State Significant Development Application – SSD 9522

Proposed Warehouse, Logistics and Industrial Facilities Hub

657-769 Mamre Road, Kemps Creek (Lot 34 DP 1118173, Lot X DP 421633, Lot 1 DP 1018318, Lot Y DP 421633 & Lot 22 DP 258414).

Table 1: Response Matrix

1 SITE PLAN (WAREHOUSE 1A, 1B, 2, 3A, 3B, 4)
1: 1000

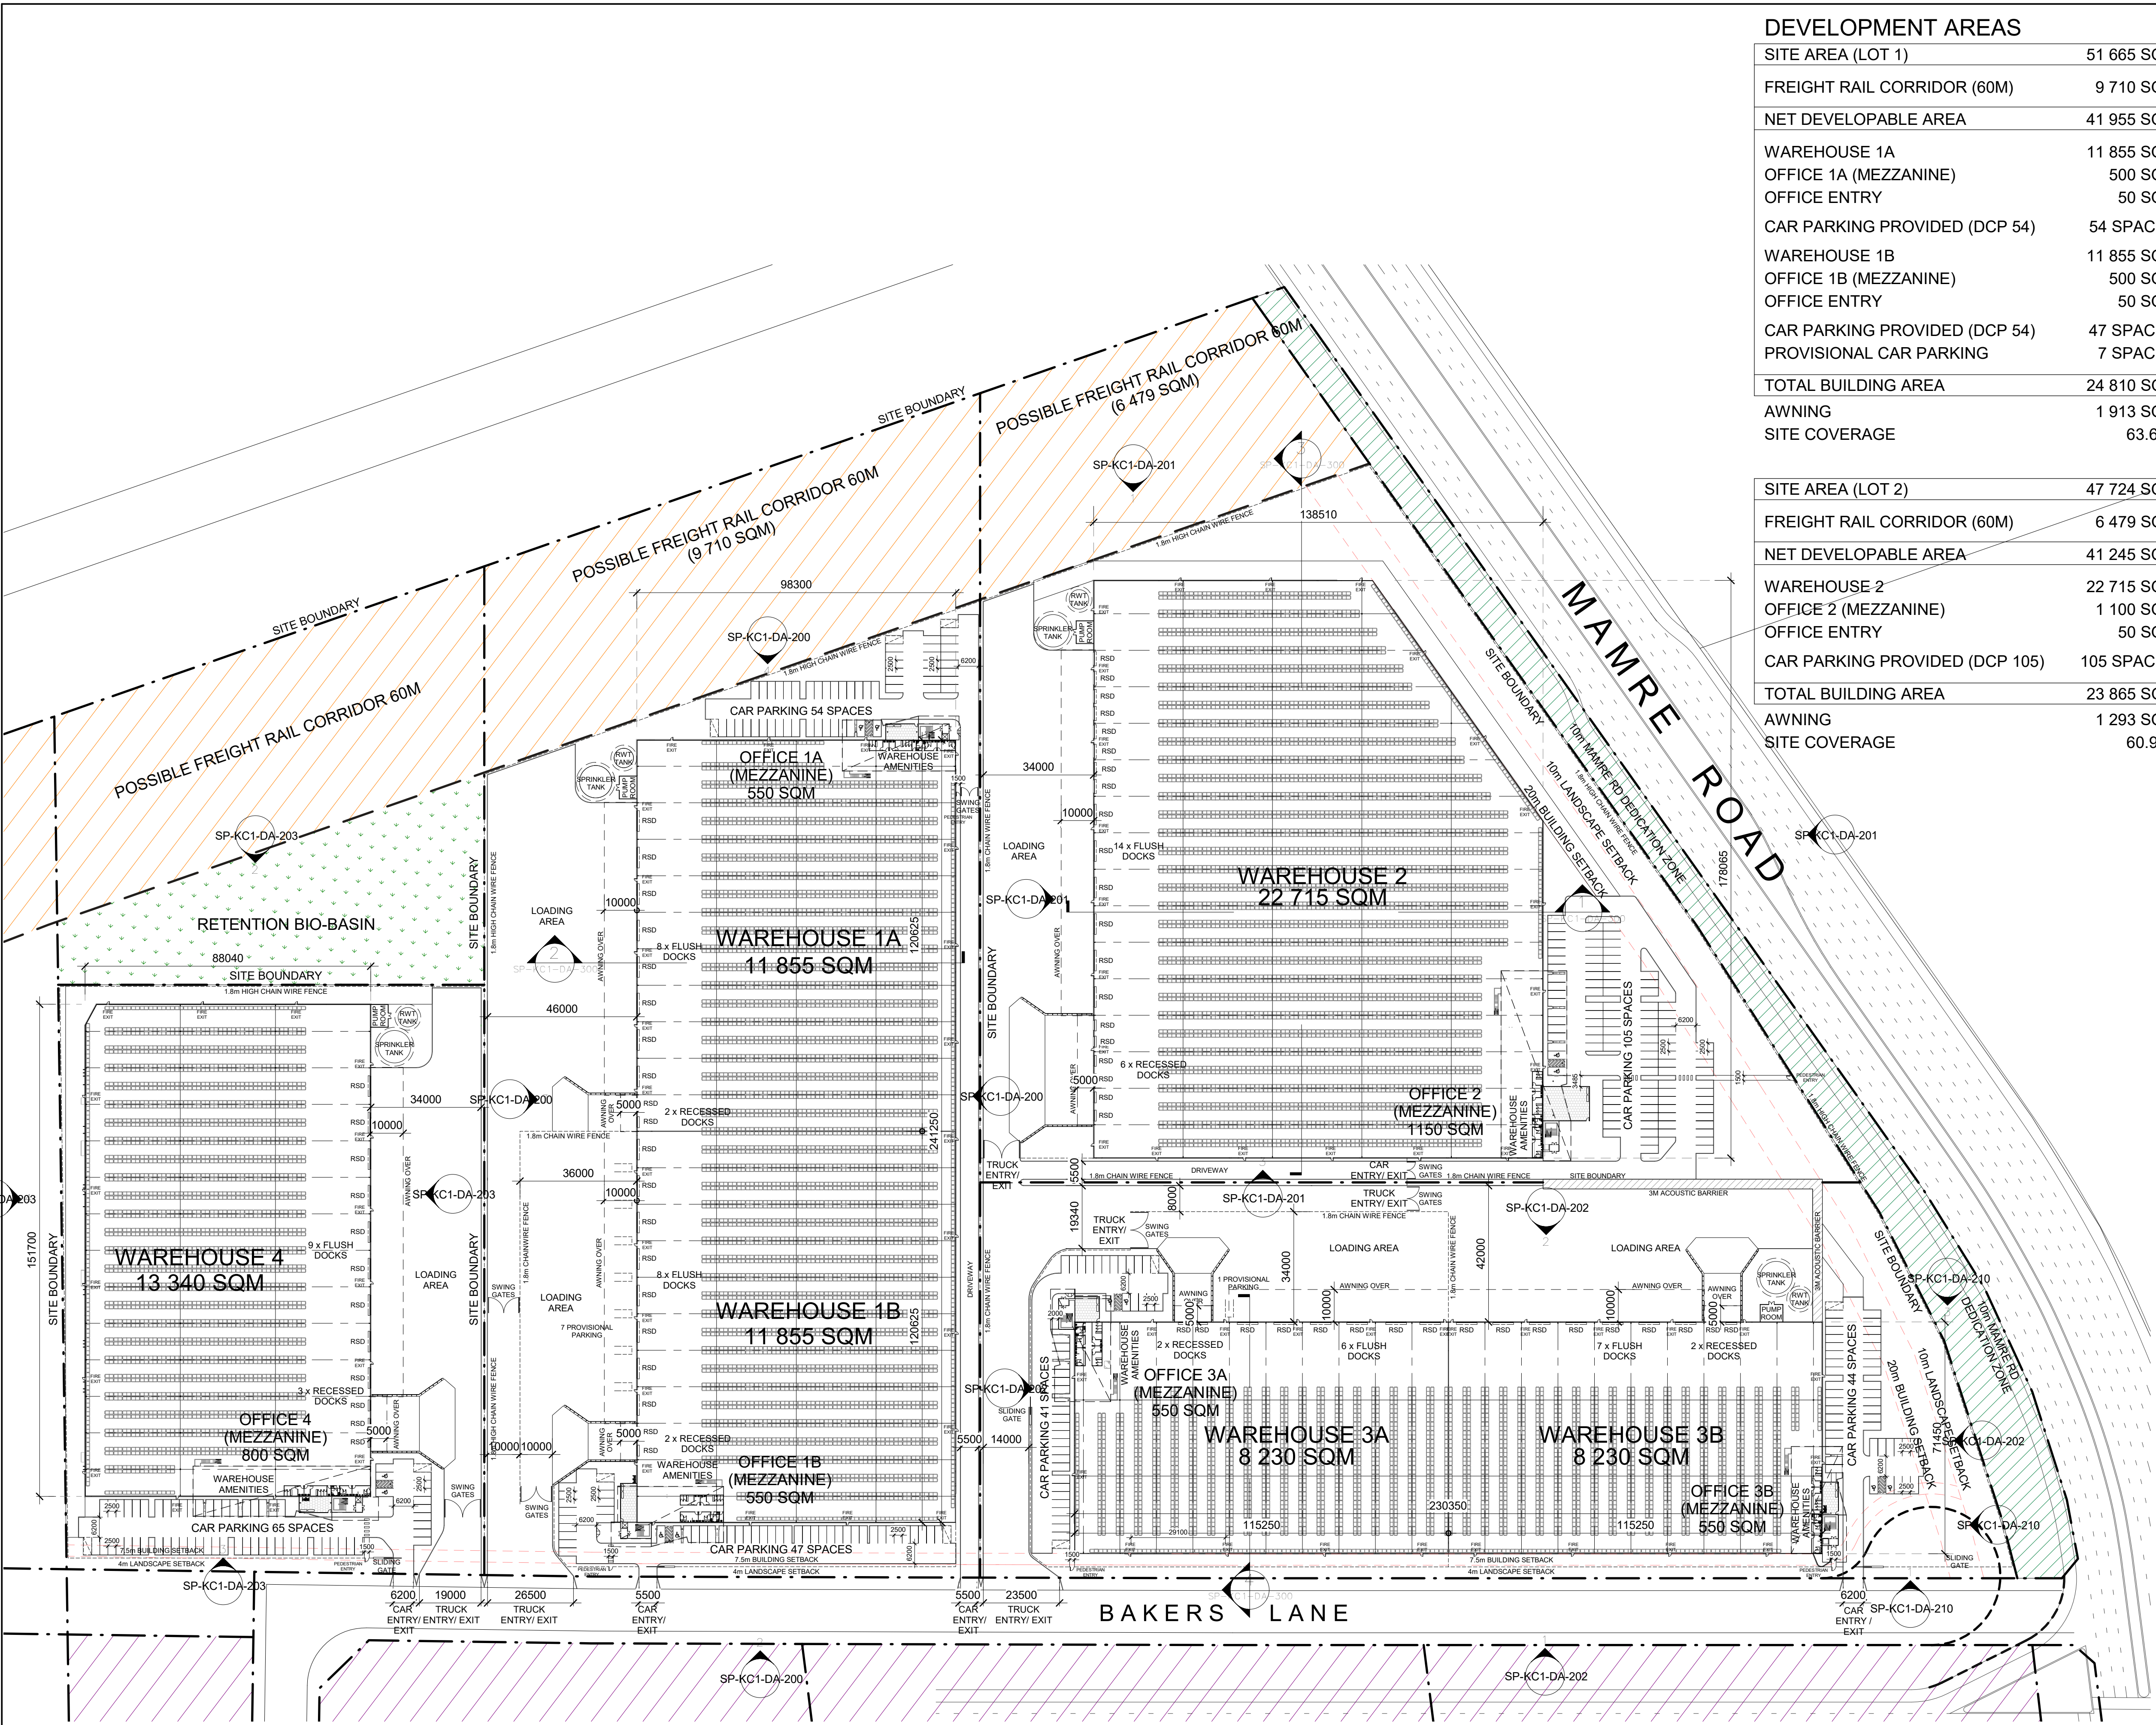
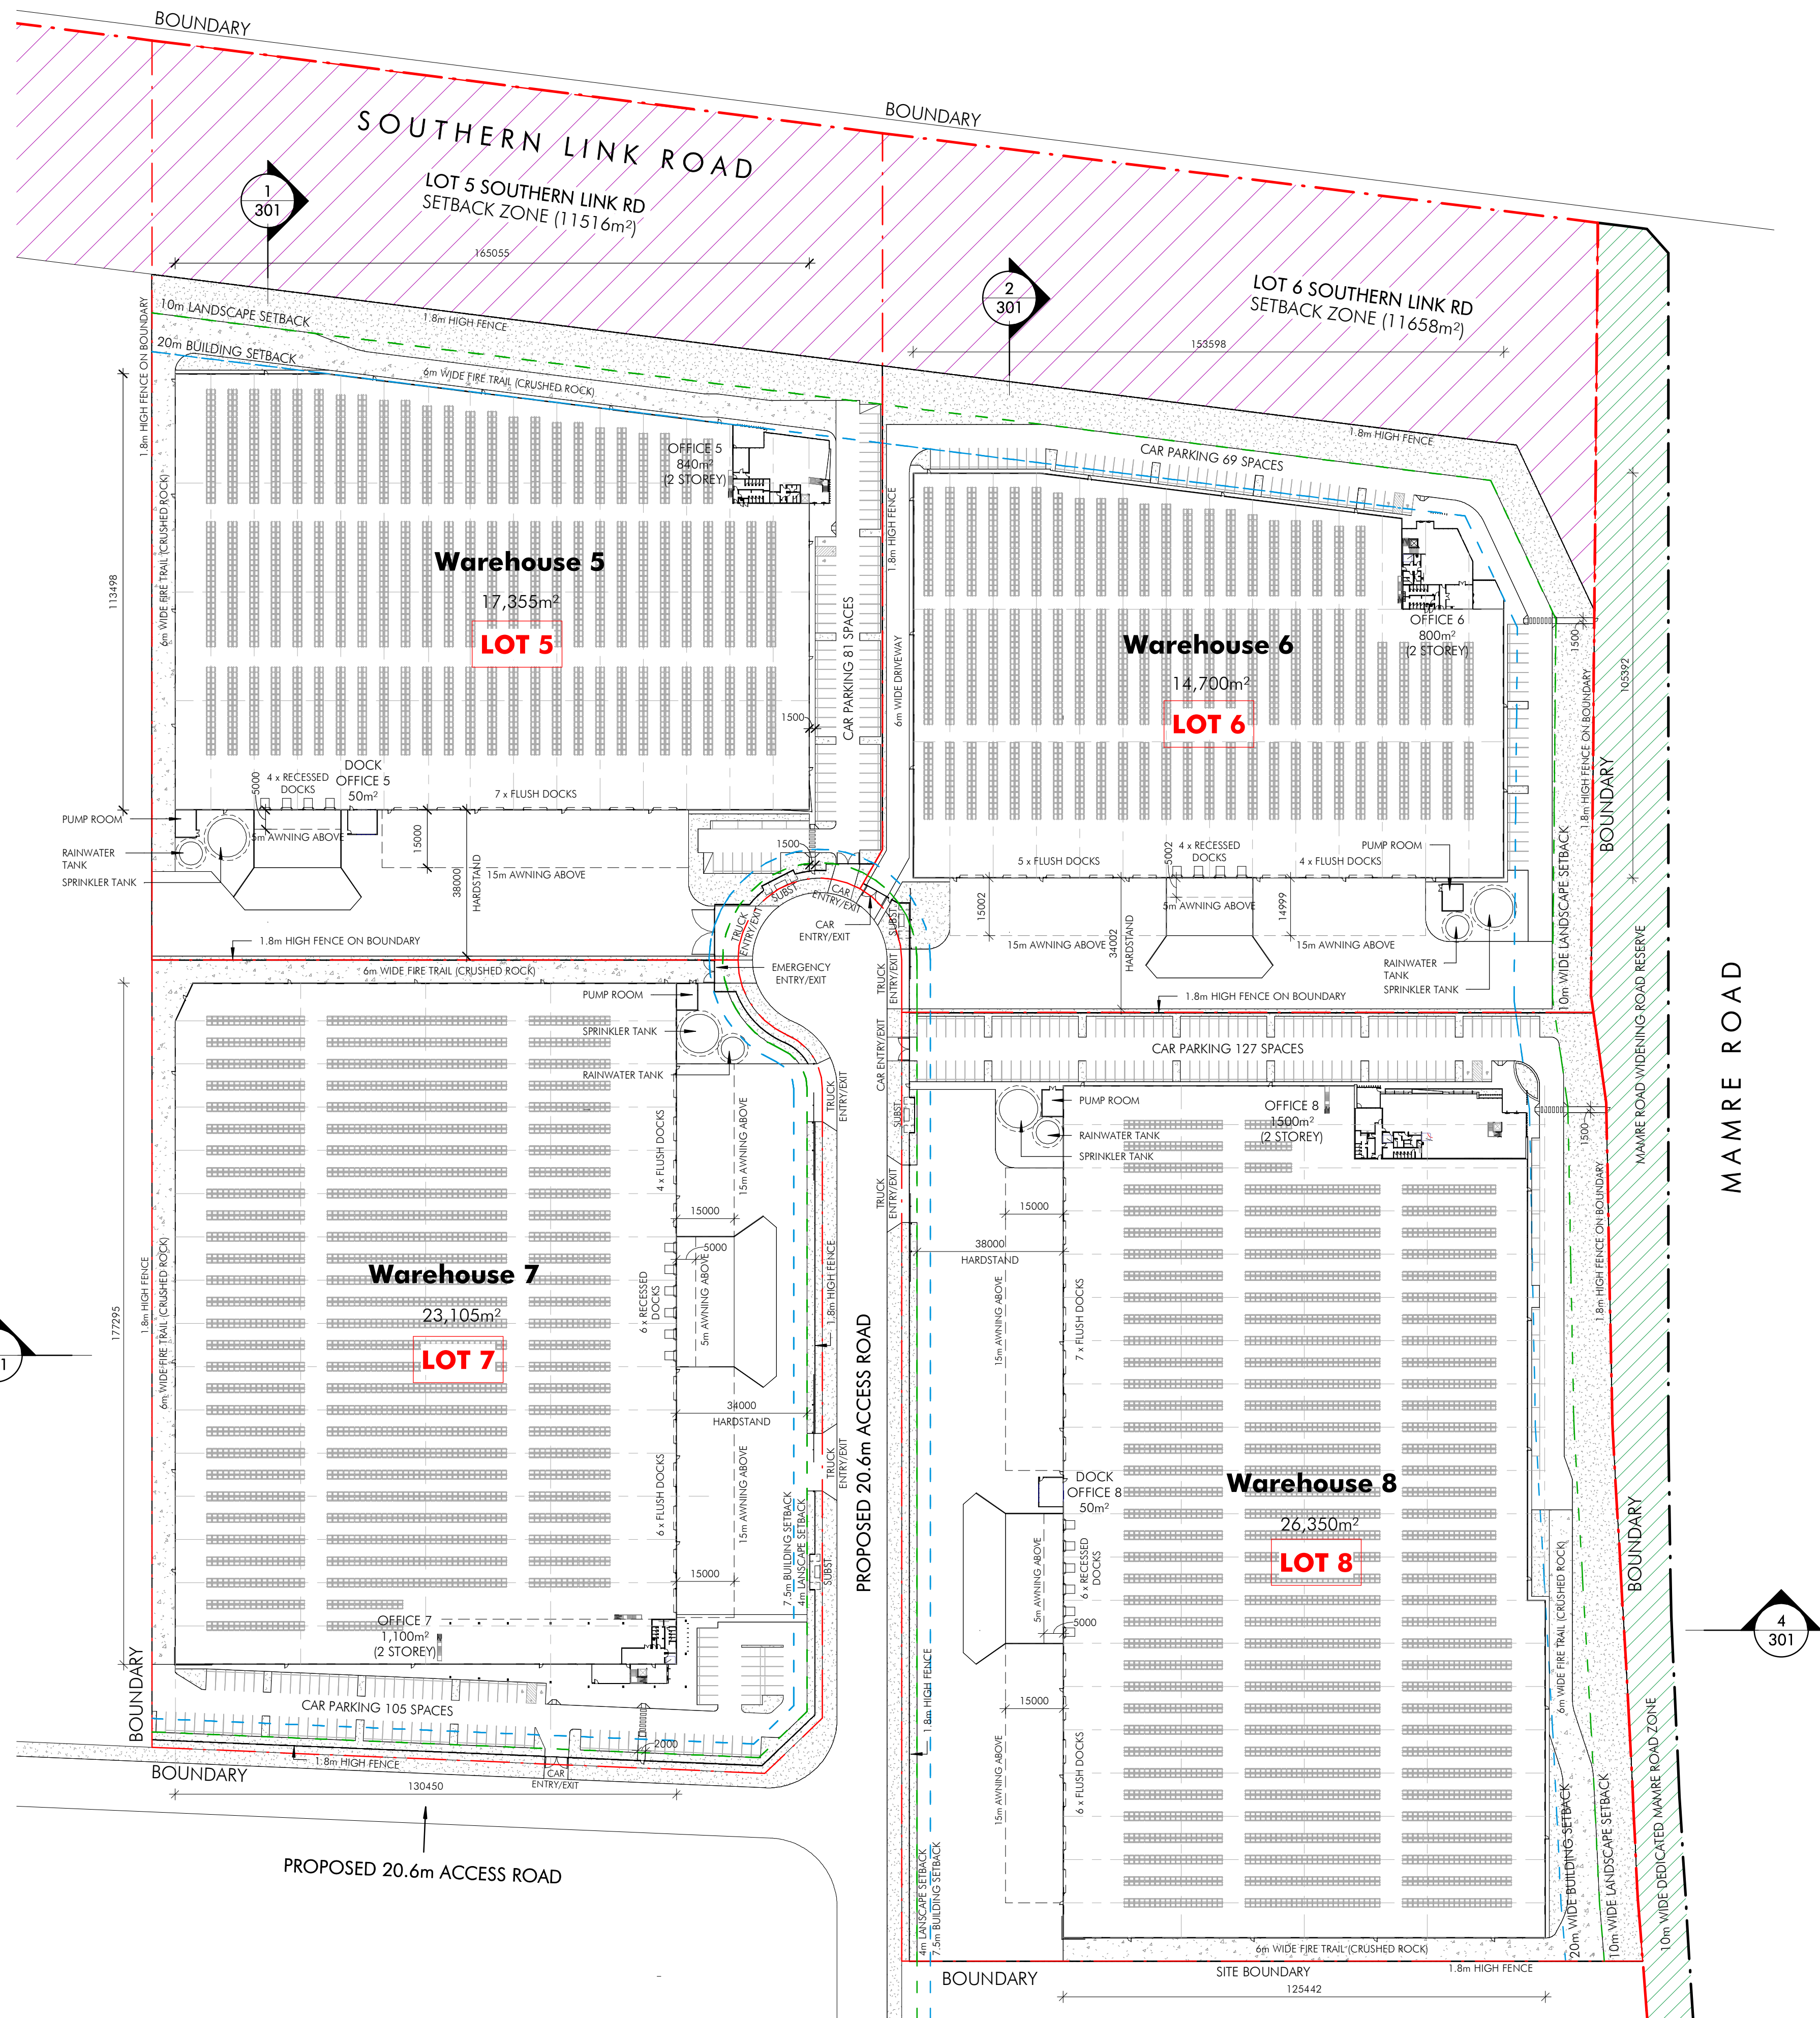
<p><i>The following inconsistencies were also identified:</i></p> <ul style="list-style-type: none"> The Architectural Plans (Appendix 6) do not provide any details regarding the 11ha green space area to the western portion of the site. The Bulk Earthworks & Building Plan (Appendix 5) show a green space as part of Stage 2 works. The Landscape Plan (Appendix 8) also shows a green space whilst the Civil Plans (Appendix 10) show an extensive OSD basin (Appendix 10). 	<p>The revised Development does not include any green space at the South Creek interface. Rather, the designated RE1 Public Recreation land is notated and reserved (refer to the revised Masterplan in Appendix 6).</p>
<ul style="list-style-type: none"> Setbacks are described in the EIS (pg 58) which are inconsistent with the setbacks shown on the architectural plans (Appendix 6). For example, the 	<p>The Architectural Plans have been revised to demonstrate consistency (refer to Appendix 7 of this Submission).</p>

1 PEDESTRIAN ACCESS ROUTE
1 : 250

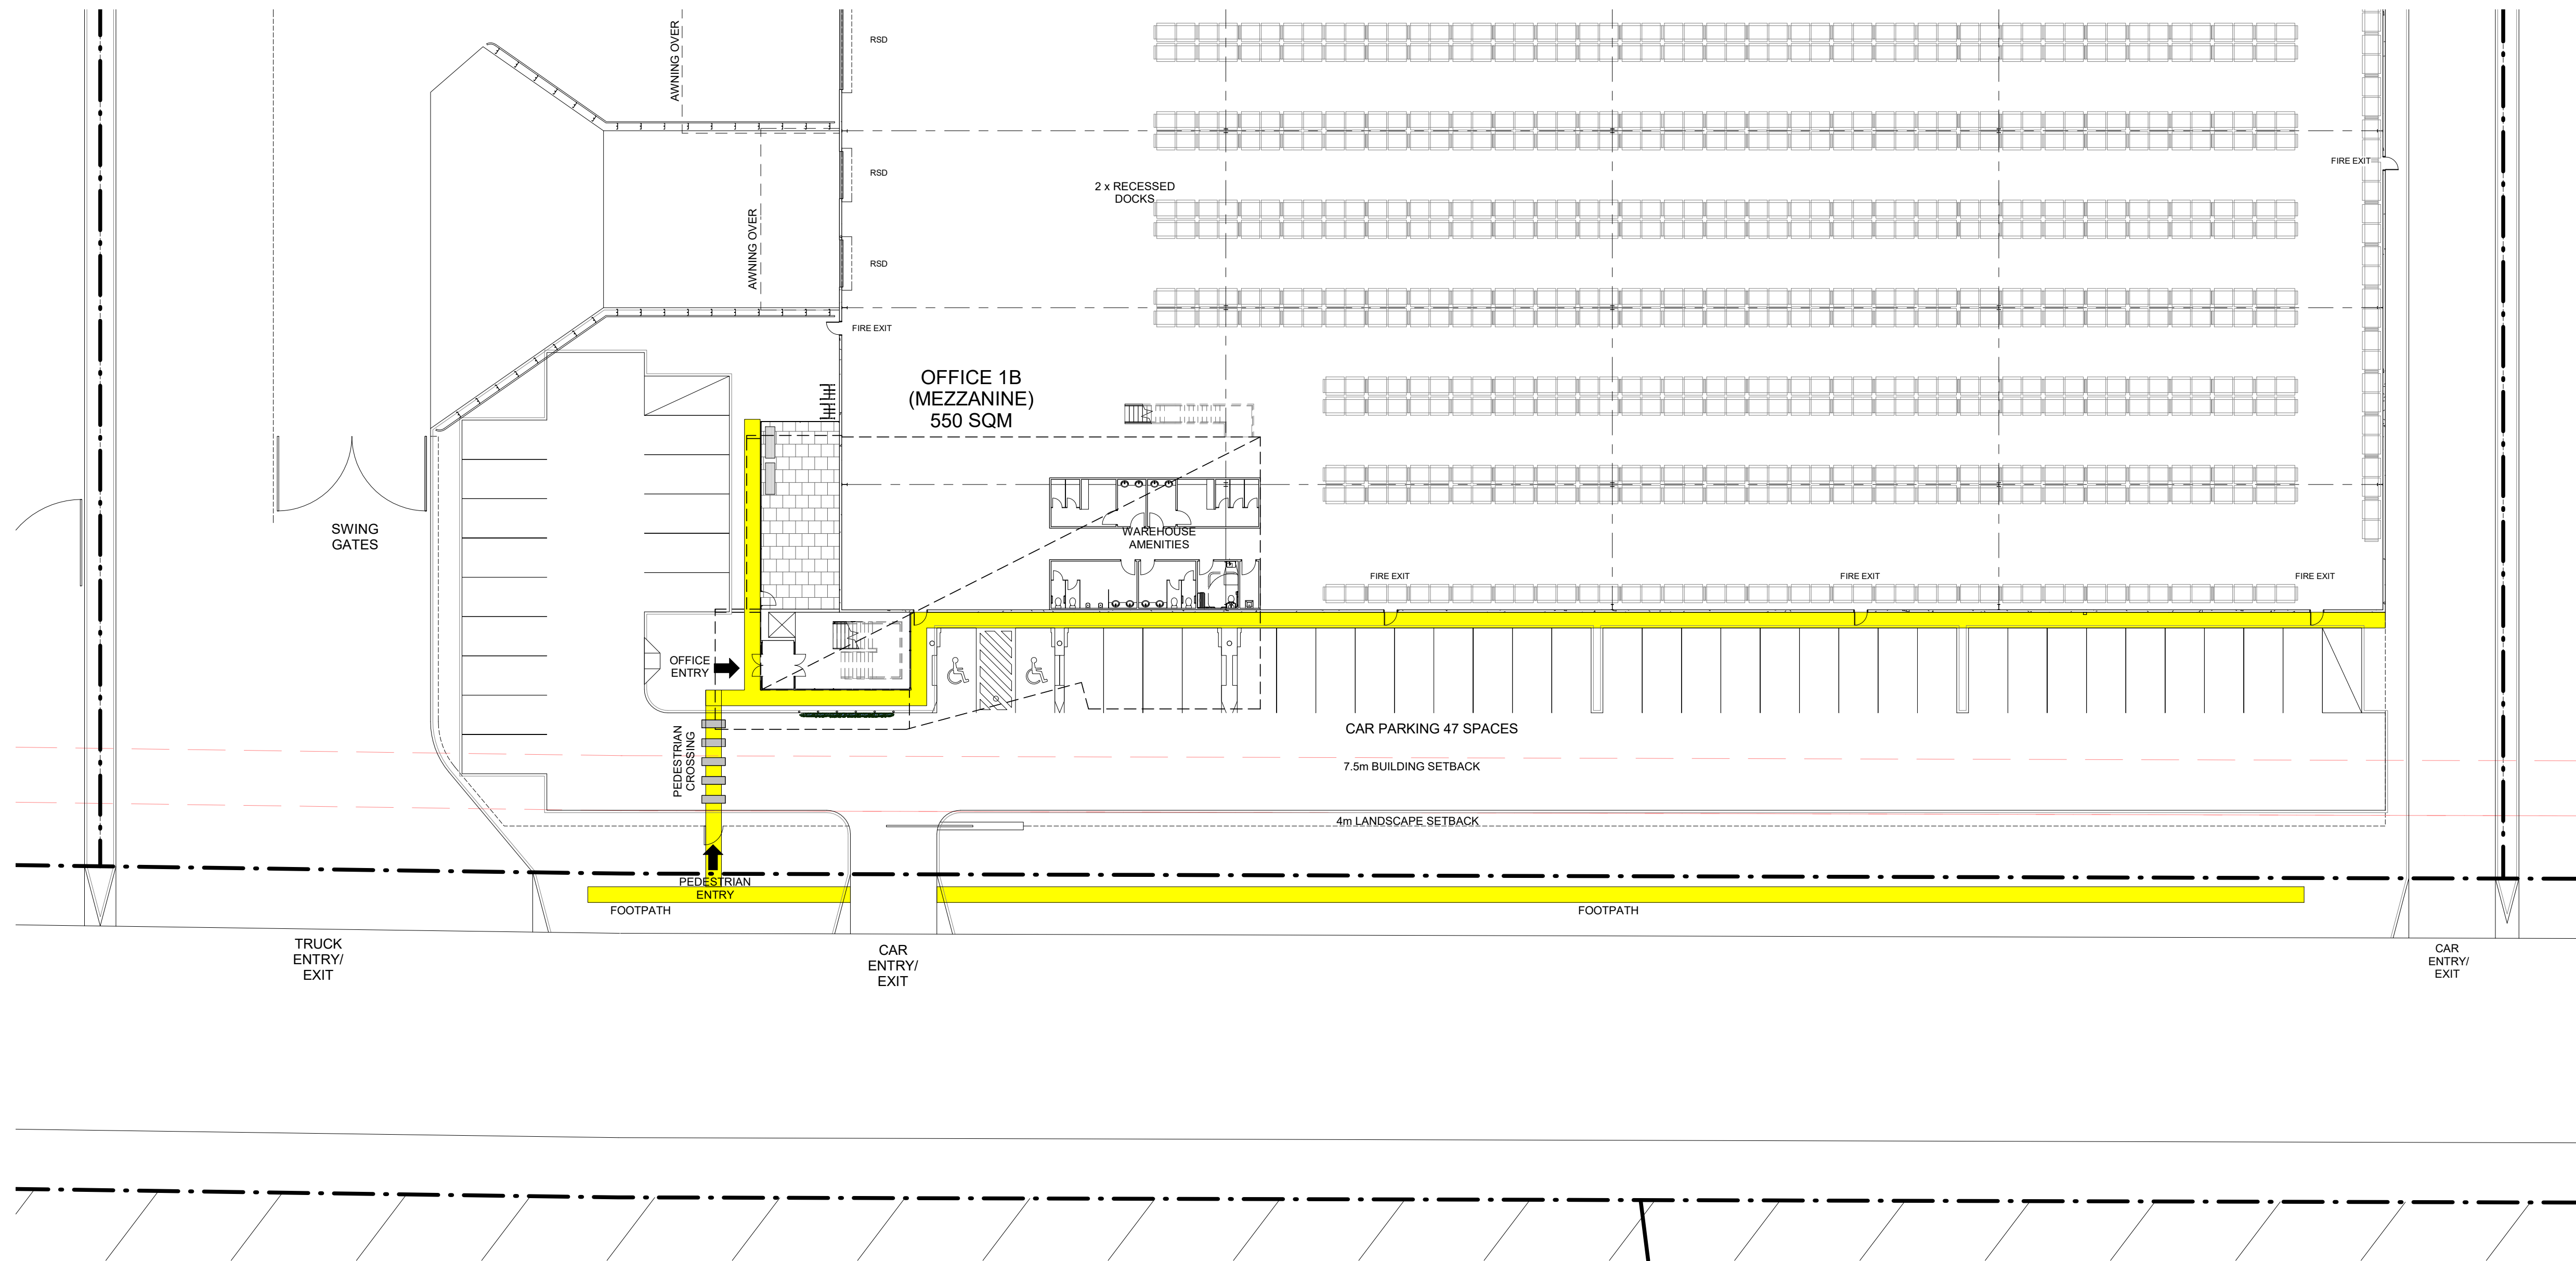
<ul style="list-style-type: none"> <i>The left in/left out connection to Mamre Road is not supported.</i> 	<p>Noted and agreed. The revised Development (refer to Appendix 16) has removed the left-in / left-out connection on Mamre Road.</p>
<ul style="list-style-type: none"> <i>A connection between the internal access roads and future development sites to the south should be provided.</i> 	<p>Noted and agreed. The revised Development (refer to Appendix 16) has allowed for the connection to the southern lots.</p>
Southern Link Road Extension:	TfNSW has confirmed that the proposed Southern Link Road (SLR) has been
